From: Paul Cann
Sent: 15 May 2017 11:58
To: Planning.Responses
Subject: RE: Planning Consultation on AL/38/17/DOC

APPLICATION AL/38/17/DOC

Registered: 27-APR-17
Site Address: The Thatched House Littleheath Road Aldingbourne BN18 0SR
Description of Works: Applicaiton for approval of matters reserved by condition imposed under AL/127/16/HH relating to conditions 3 for samples of materials & finishes & 5 for surface water drainage.

| Drawing<br>Number                                                                                                                        | 1727/D1.1 | Revision    | -  |

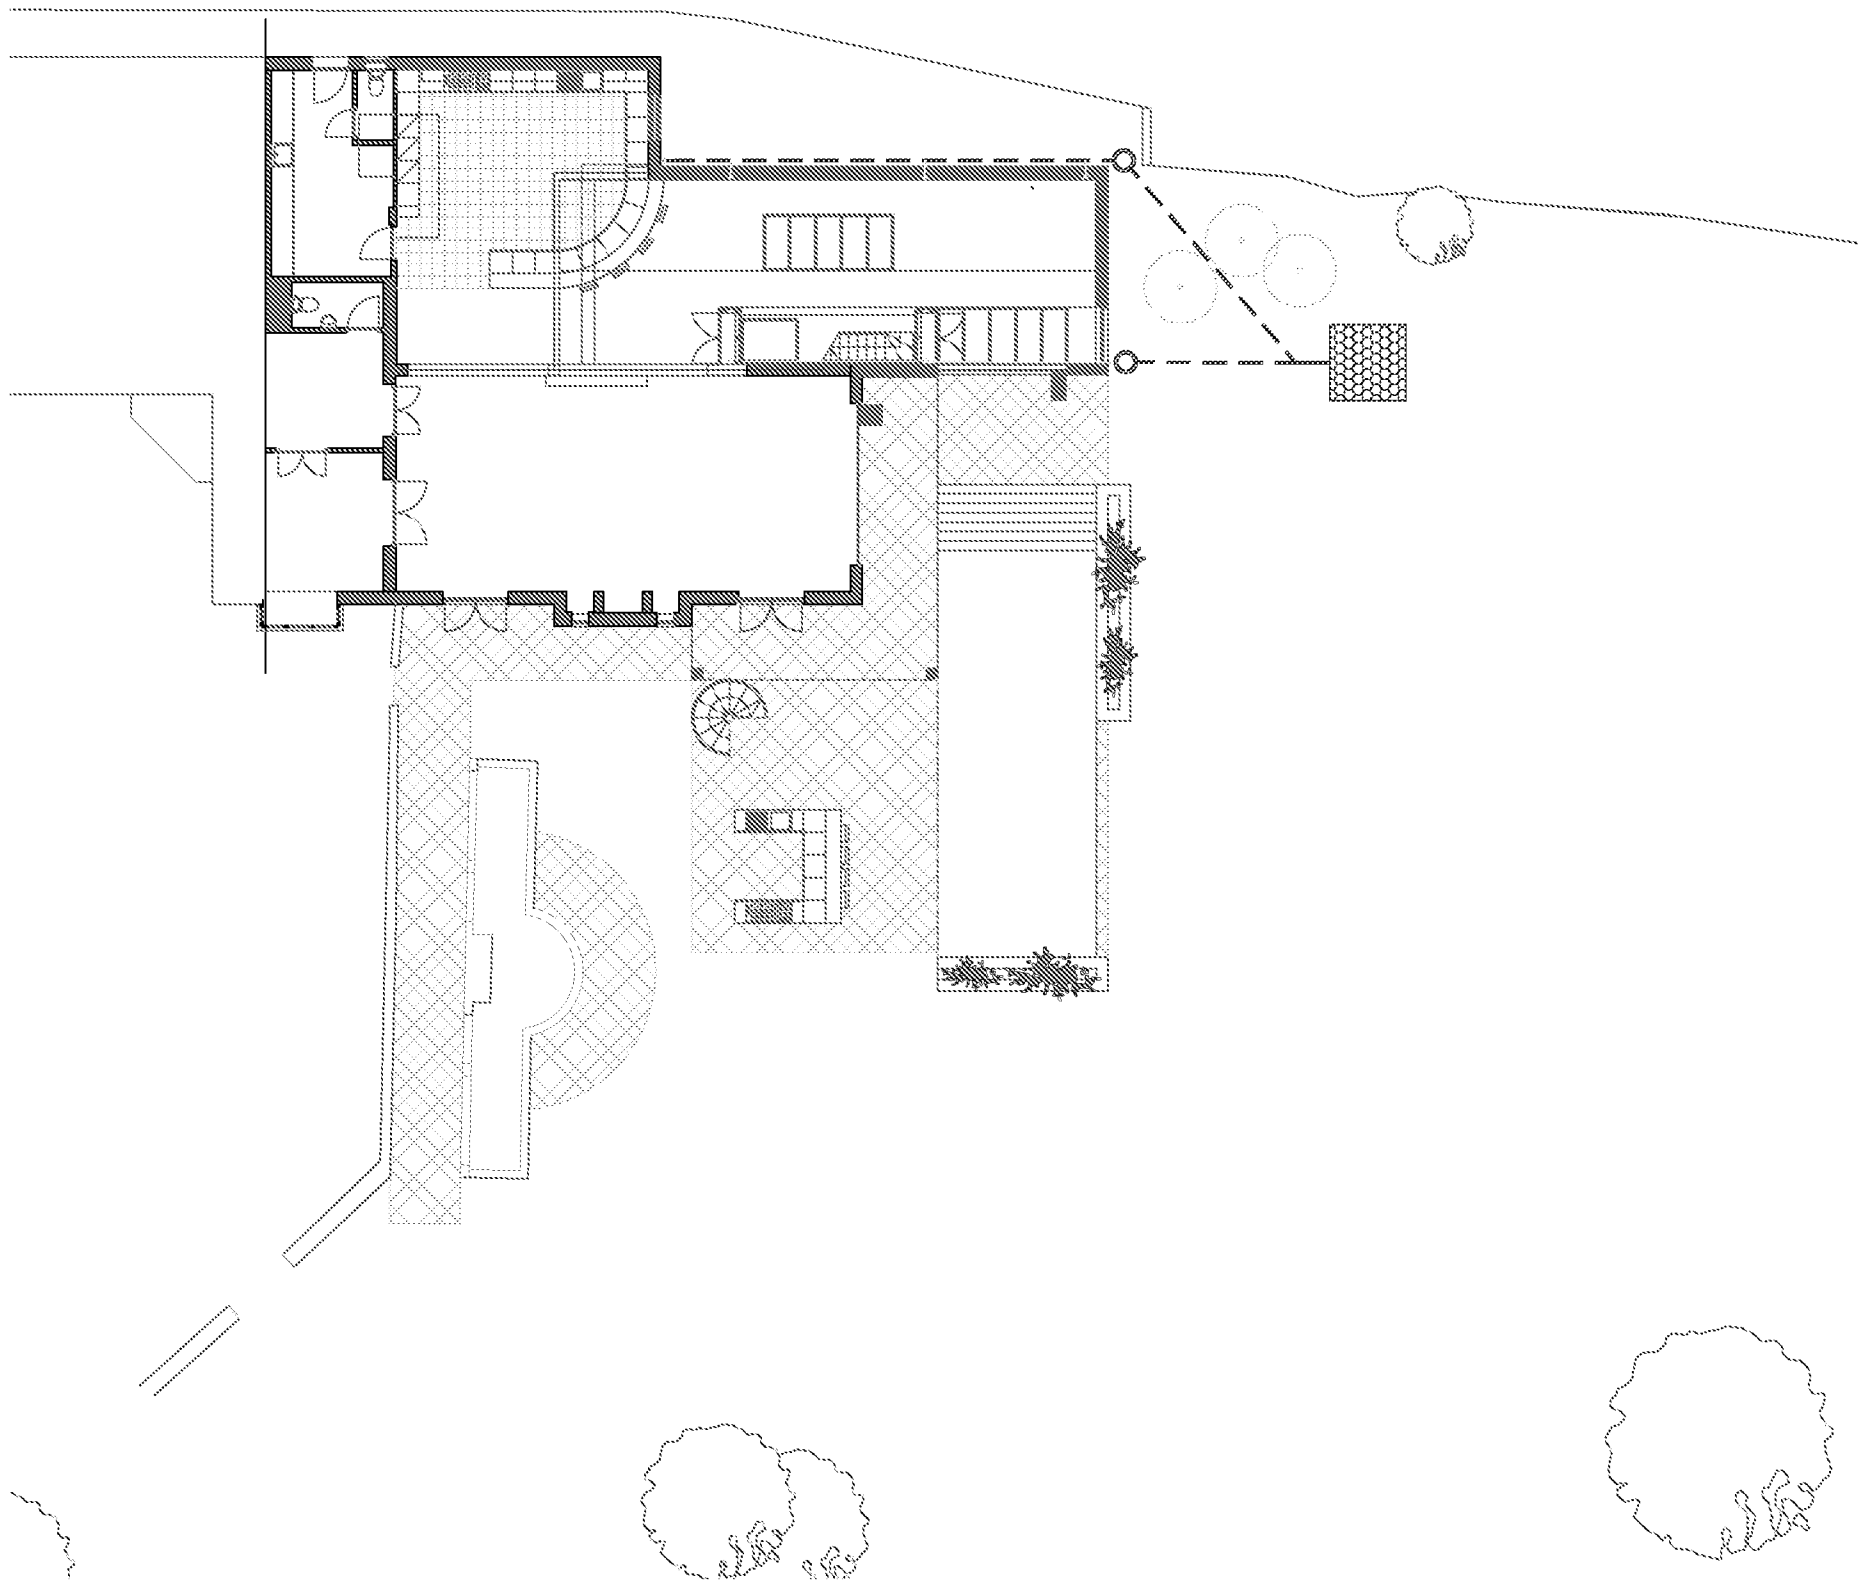
To support the proposal, the applicant needs to provide a construction detail (cross section) for the crated soakaway, to include all relevant levels of incoming pipes, etc. Silt trap manhole detail is also to be provided.
